Board Order
ABP-312523-22

Inspector's Report ABP-312523-22

Whether the Drawing No. DoE3, elevations/fenestration pattern is materially consistent with the granted Planning PP/13/94 & 18/178 Extension of duration, is or is not development and is or is not exempted development.

63 Threadneedle Road, Salthill, Galway

East Elevation - Rear Garden - Declaration of Exemption 2021
1:100

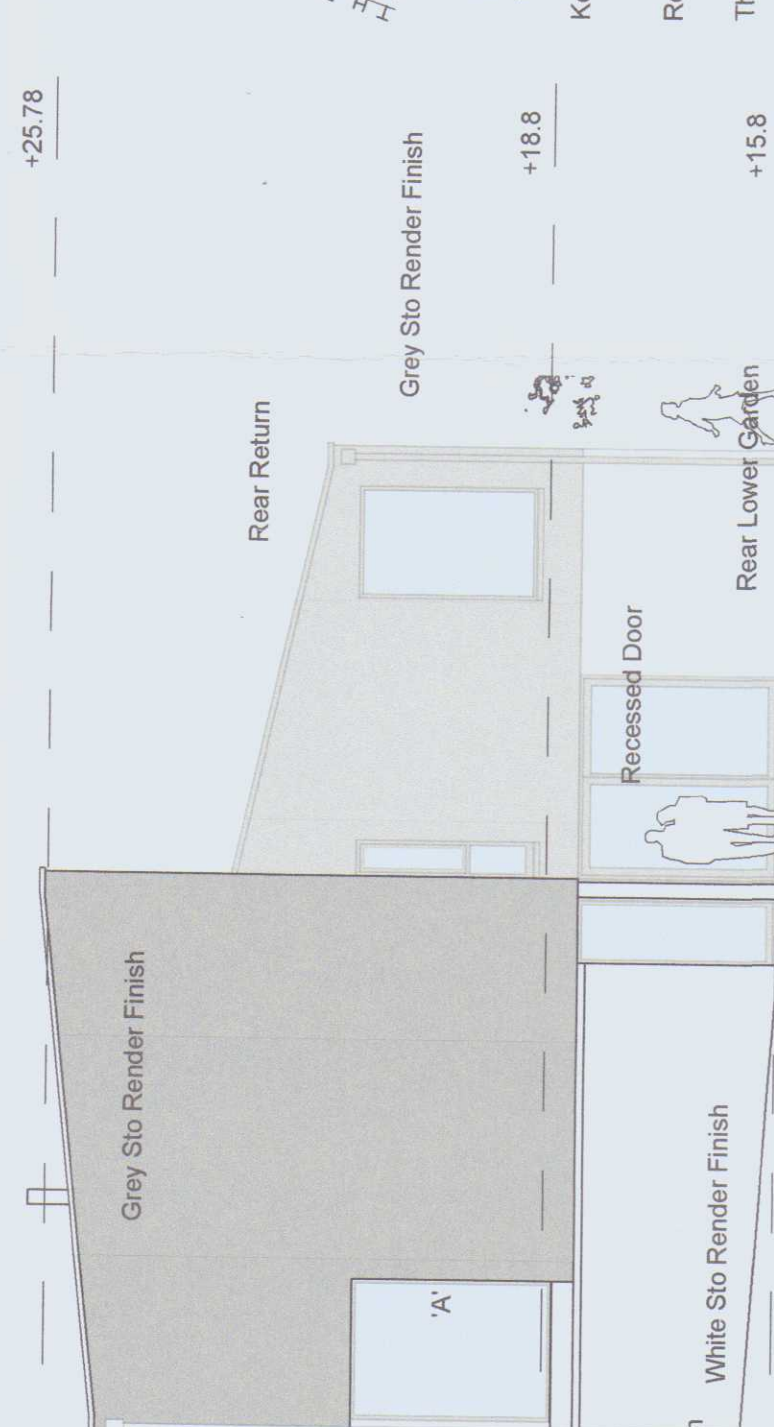
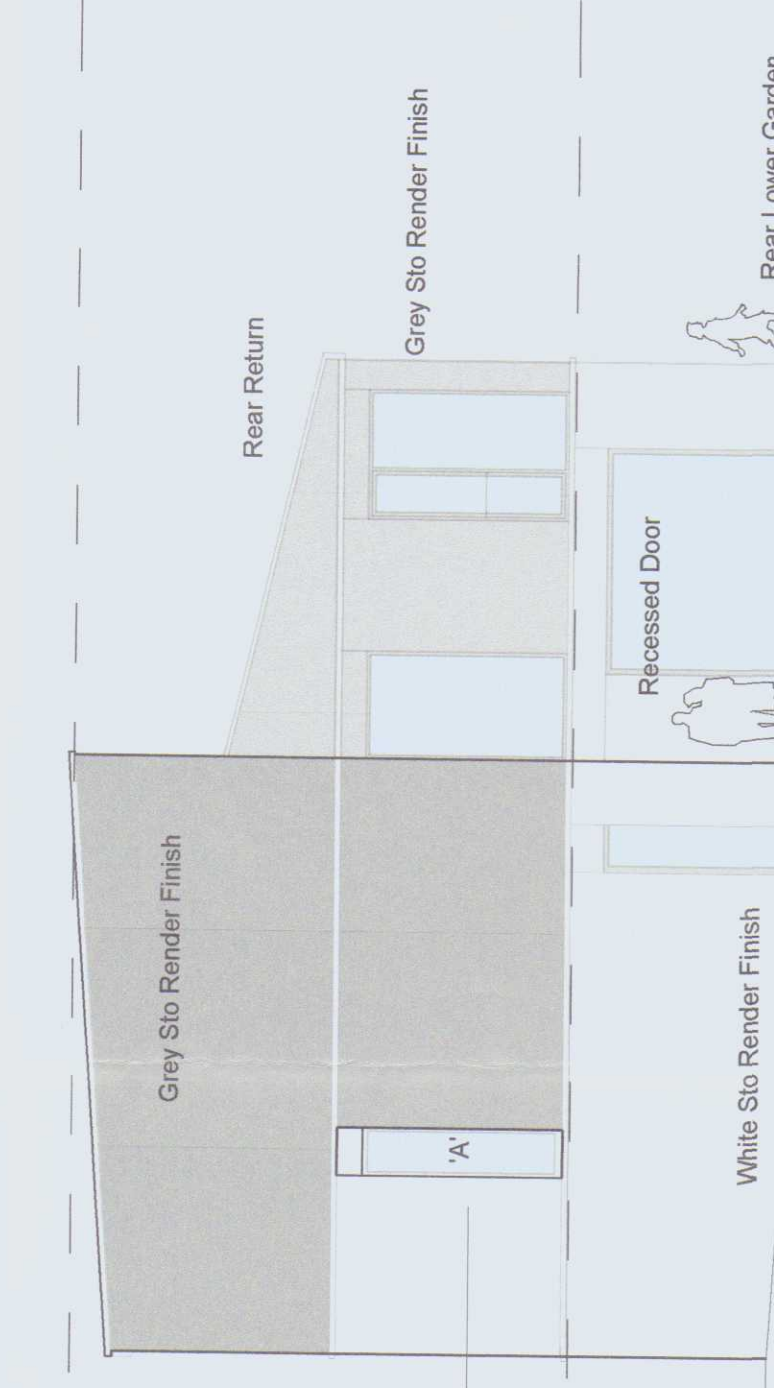
East Elevation:

- Changes to size and location of windows on all floors, the omission of a window at first floor level and enlarged window at first floor level.

South Elevation - to South Boundary - Declaration of Exemption 2021
1:100

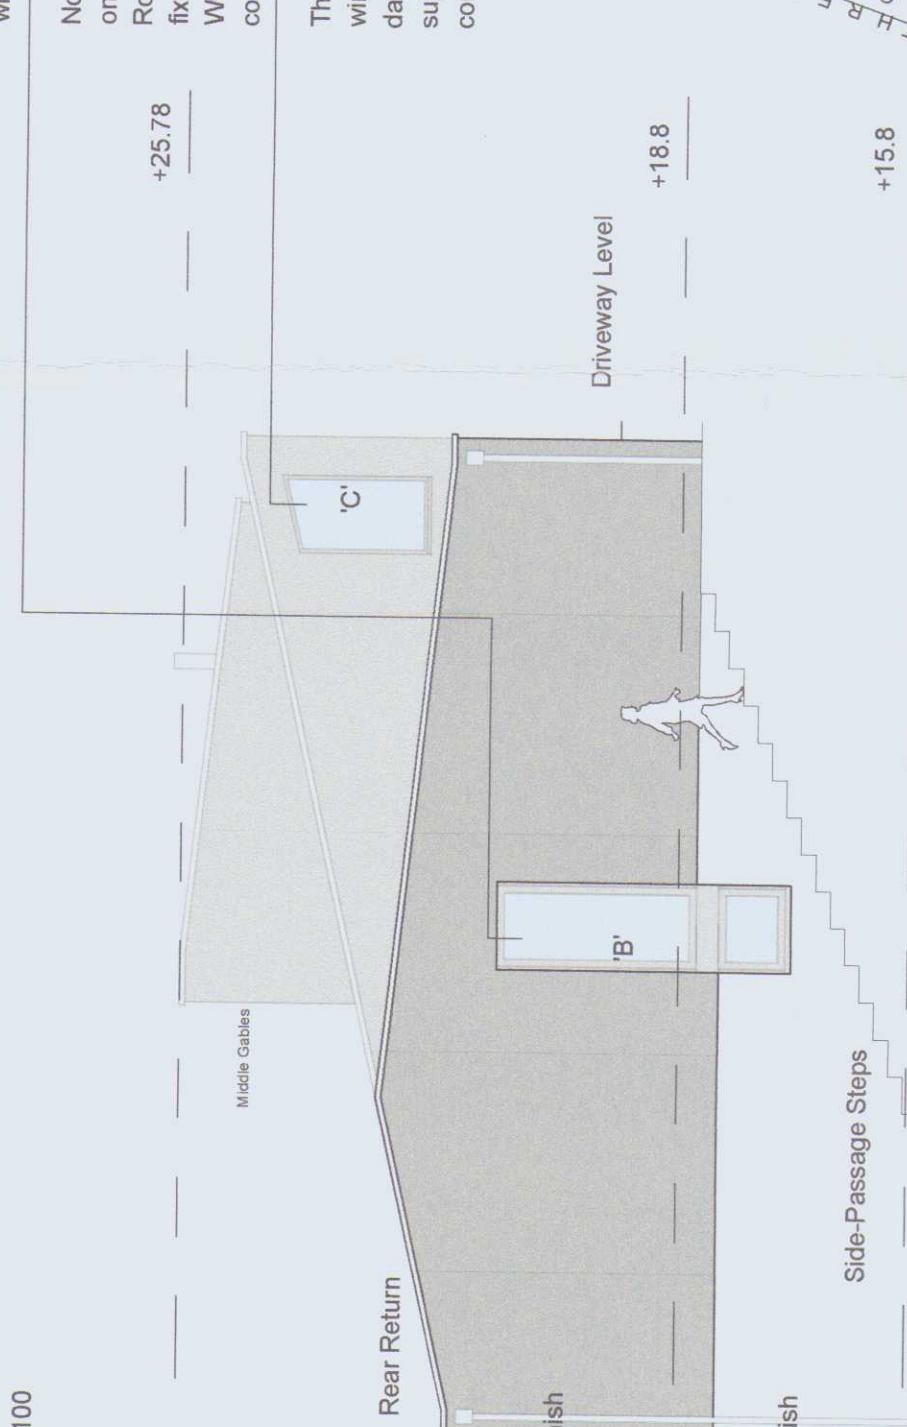
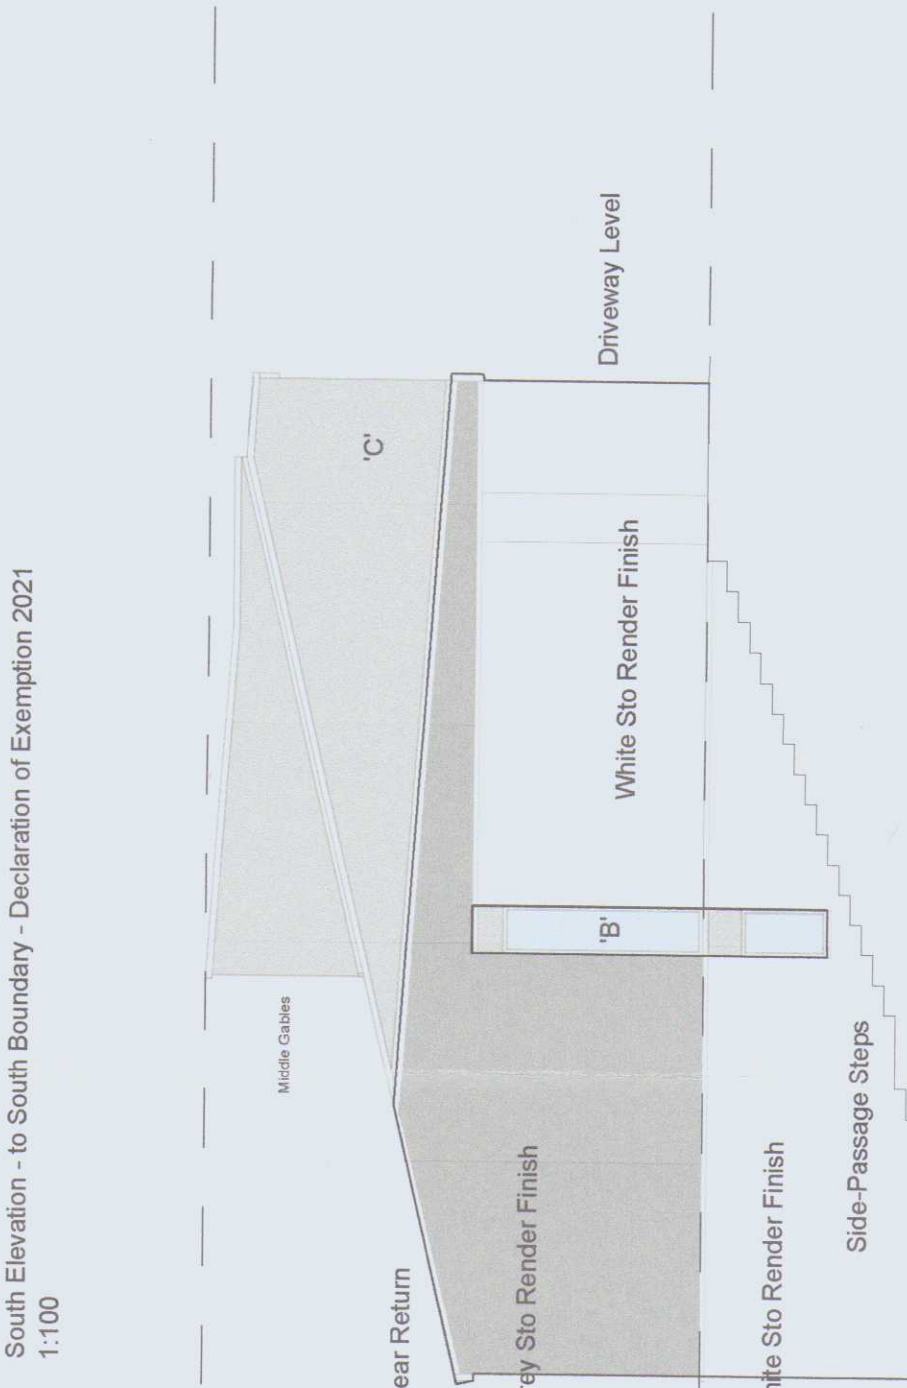
- 2.3. Details of the changes are as follows;
 - South Elevation (Window 'A'):
 - permitted window c. 1.8 m x c. 2.5 metres v as constructed c. 0.5 metres x c. 2.6 metres. 'Window A' is a fixed pane, non-opening window with translucent glass, serving a WC.

- 'Window A' cannot be considered 'de minimis', and contravenes Condition No. 1 of PA. Ref. 13/94. Article 9 (1) (a) (i) of the Planning and Development Regulations, 2001, as amended, limits exempted development.

- 'Window A' as permitted served a void and did not result in any overlooking.

North Elevation - to North Boundary - Declaration of Exemption 2021
1:100

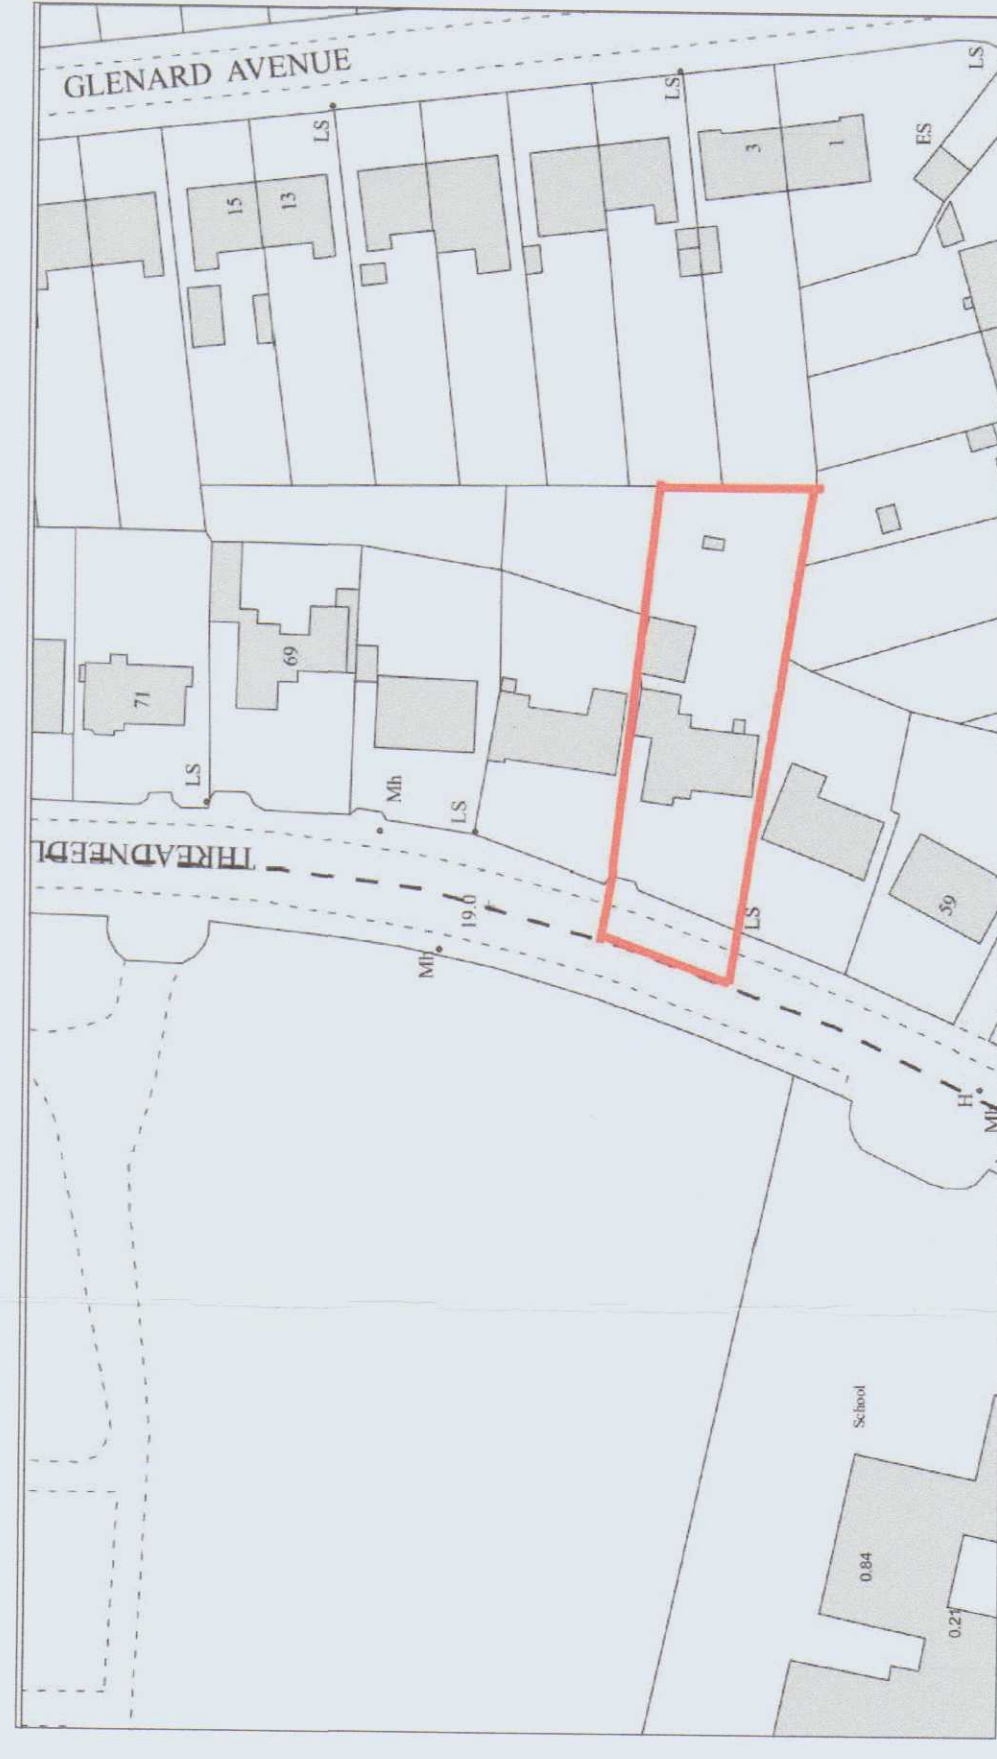
North Elevation (Windows 'B' & 'C')

- permitted window c. 1.2 m x c. 1 metre and c. 1.2 metres x c. 2.5 metres v as constructed c. 0.5 metres x c. 1 metre and c. 0.5 metres x c. 2.5 metres. 'Window B' is a fixed pane, non-opening window with translucent glass.
- Omission of high level window ('Window C').
